CITY OF ALBUQUERQUE

Re: AT&T
10036 Coors Blvd. Bypass NW
30-Day Temporary Certificate of Occupancy- Transportation Development
Engineer's Stamp dated 3-25-16 (B13D014A)
Certification dated 5-22-17

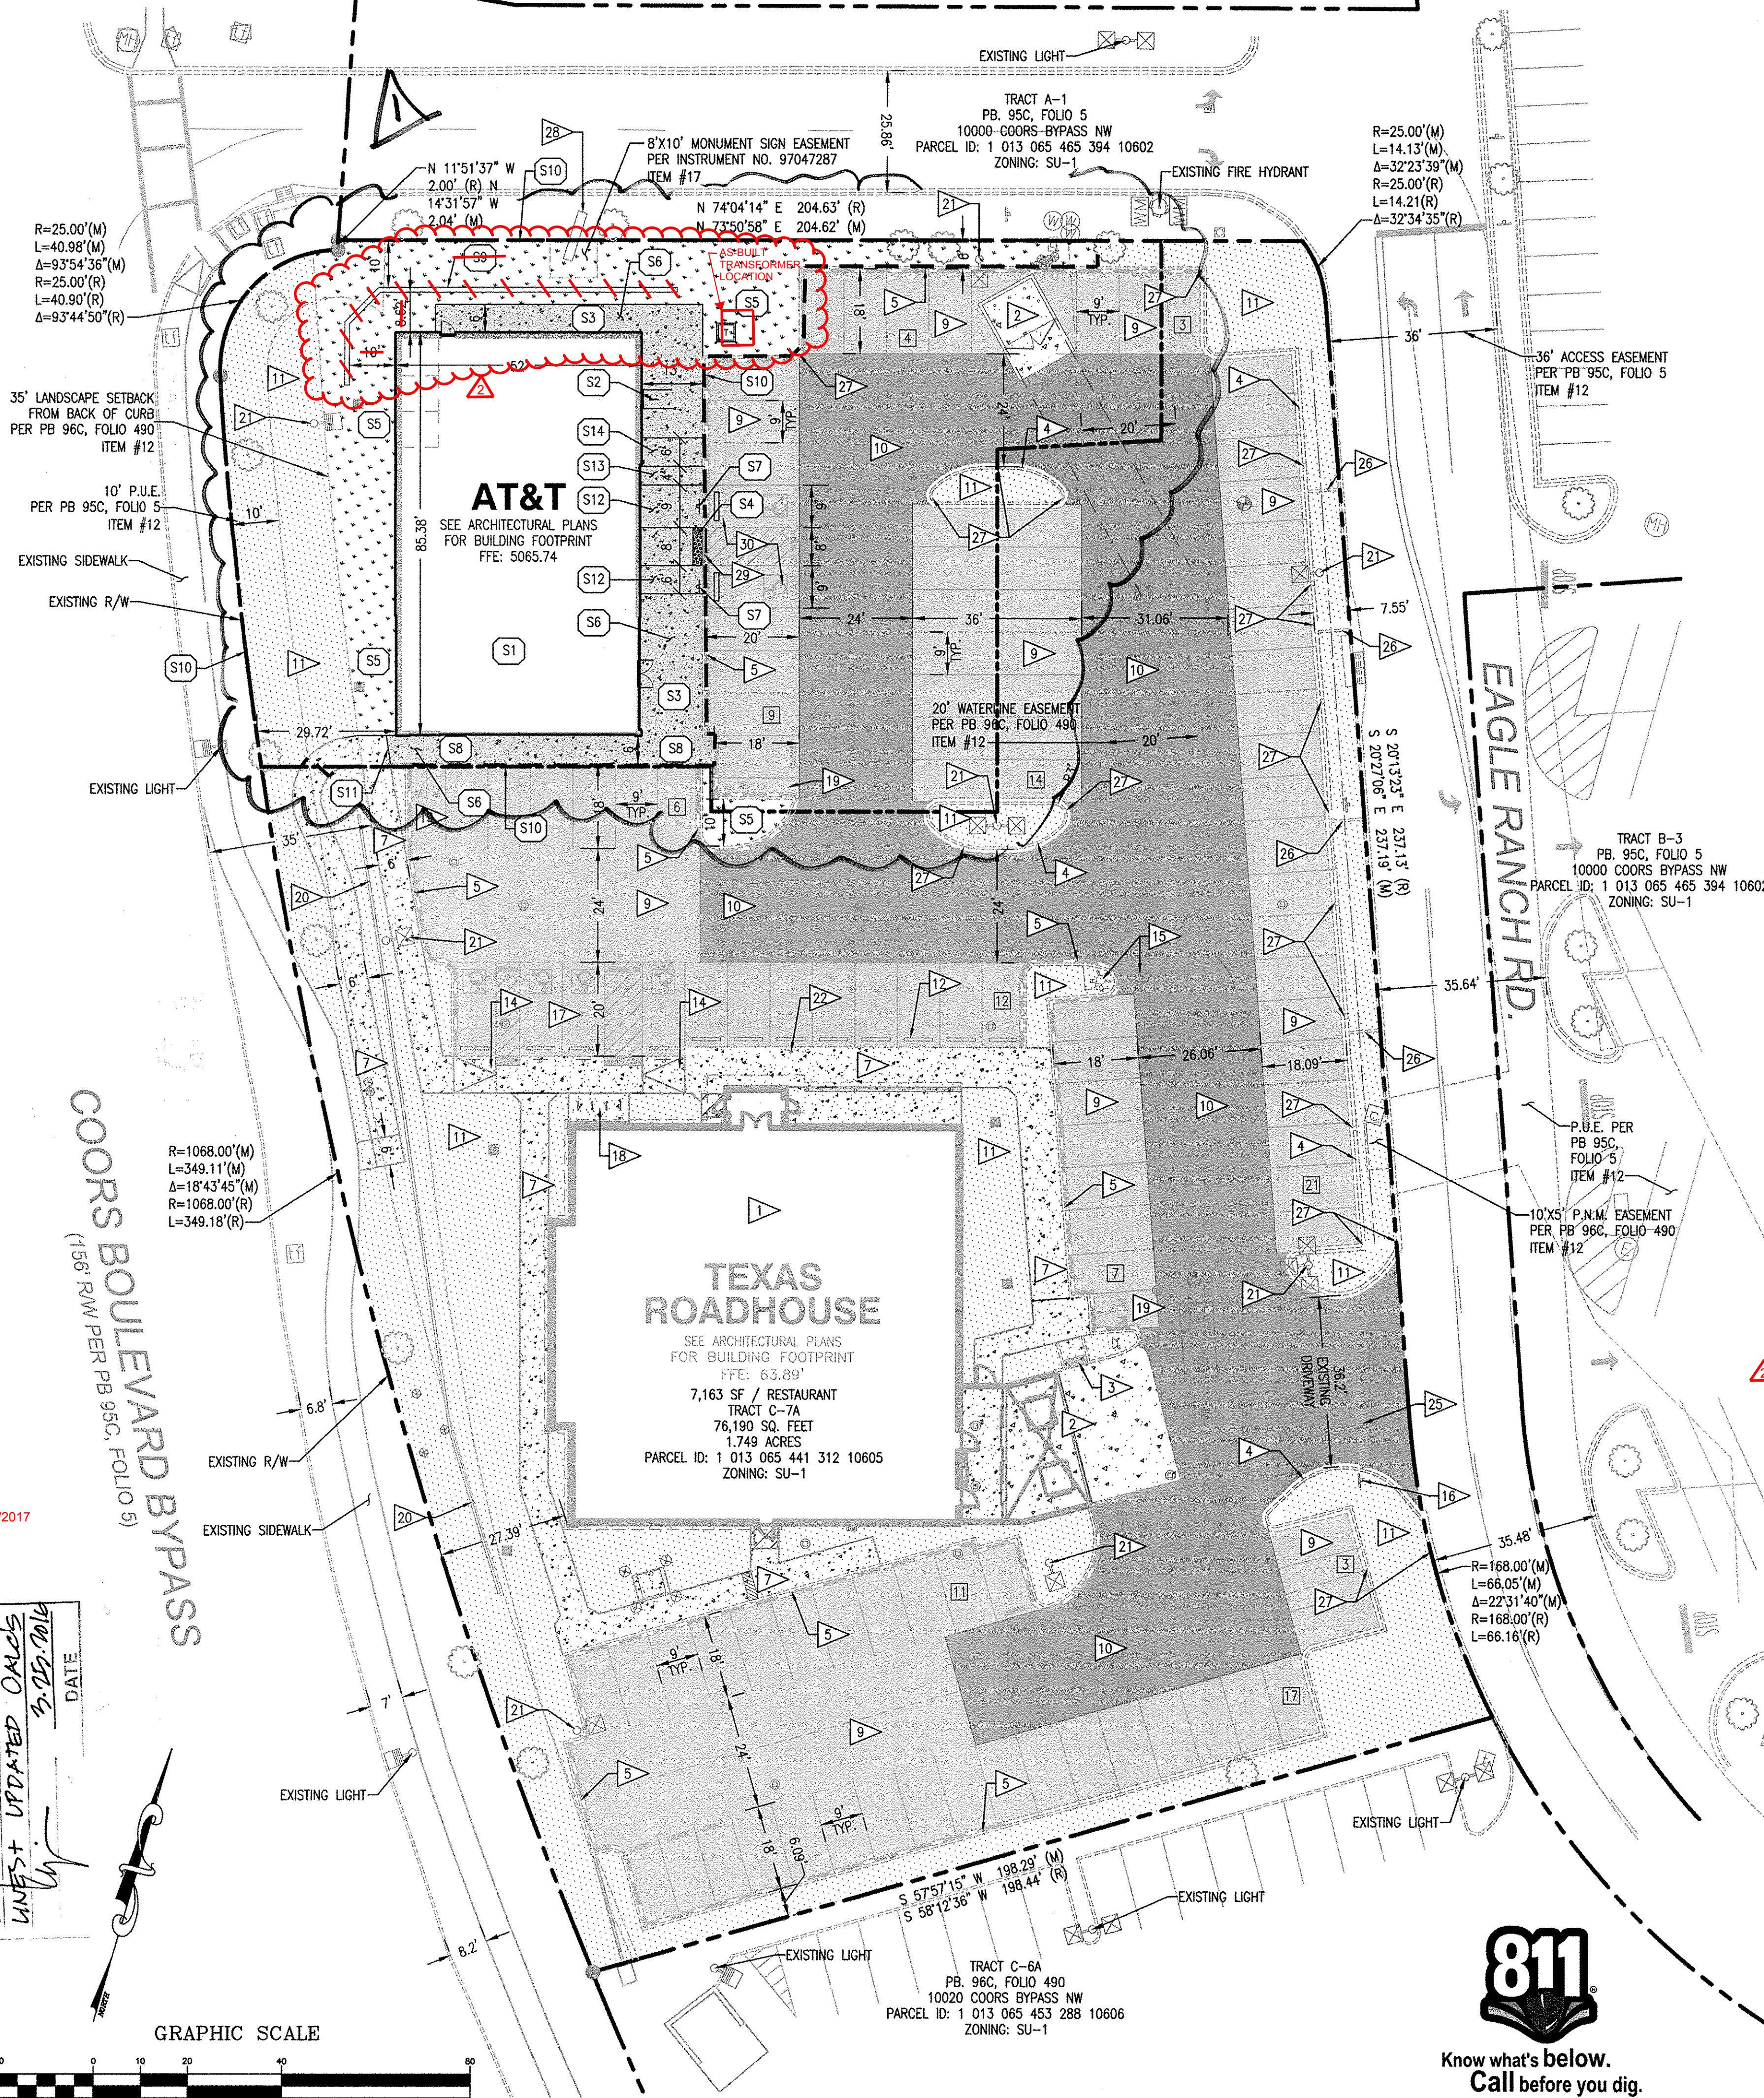
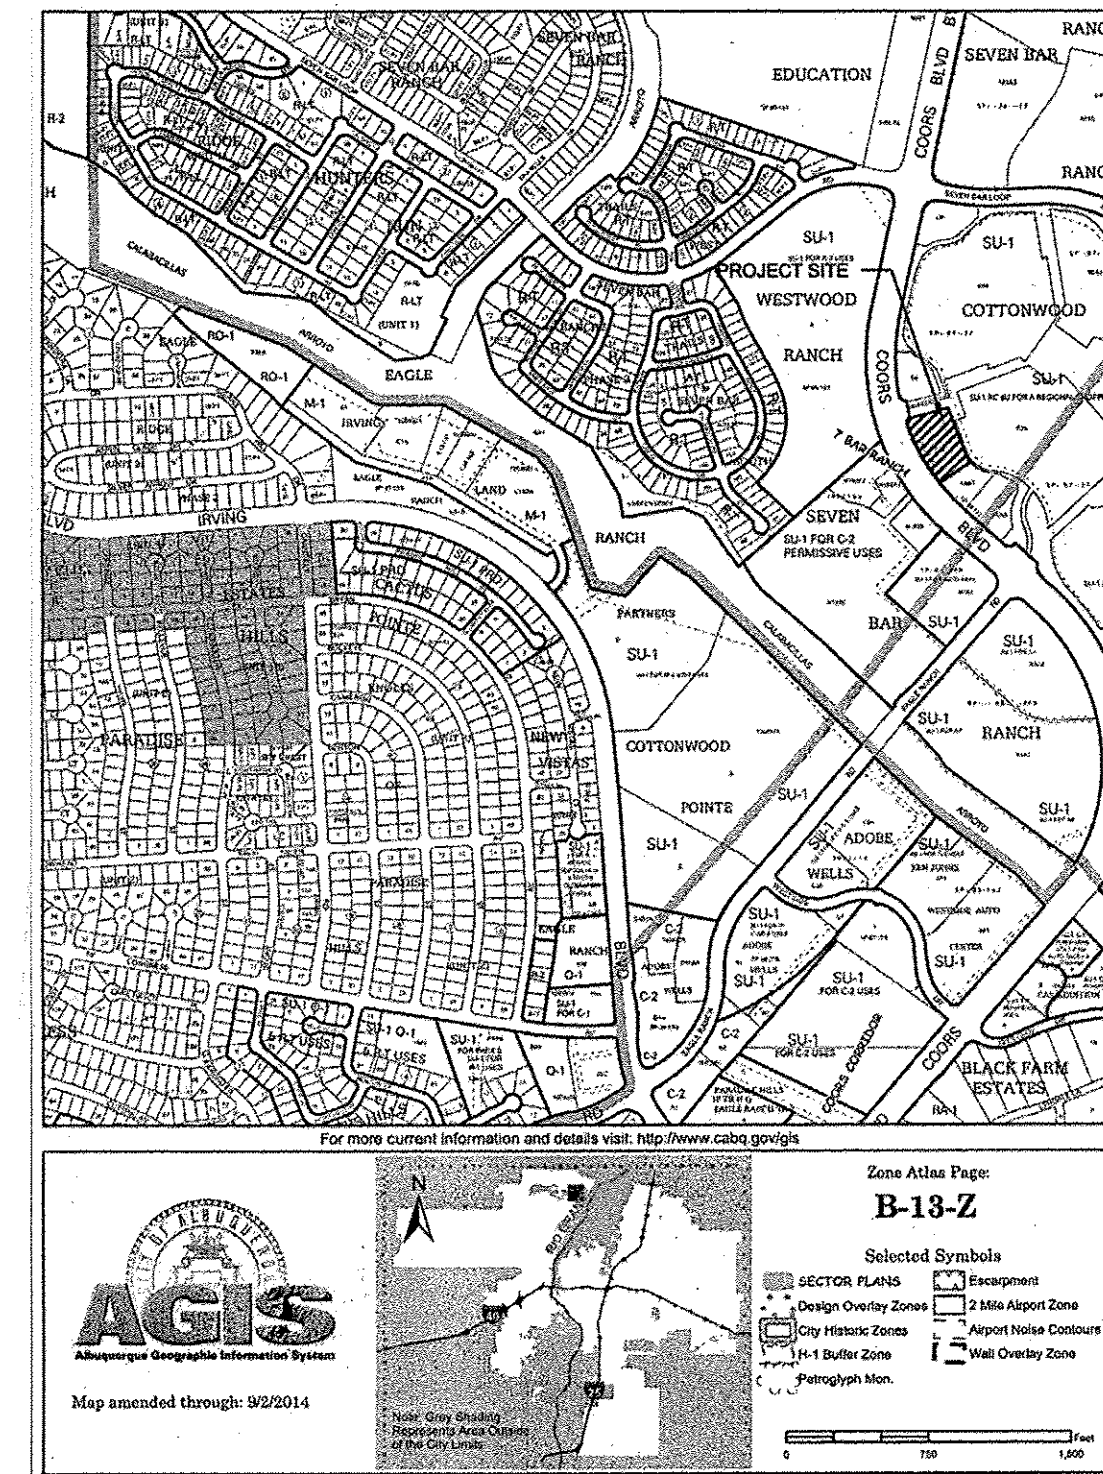
1. Add Motorcycle parking sign.
2. The ADA accessible parking sign must have the required language per 66-7-352.4C NMSA 1978 "Violators Are Subject to a Fine and/or Towing." Please call out detail and location of HC signs.
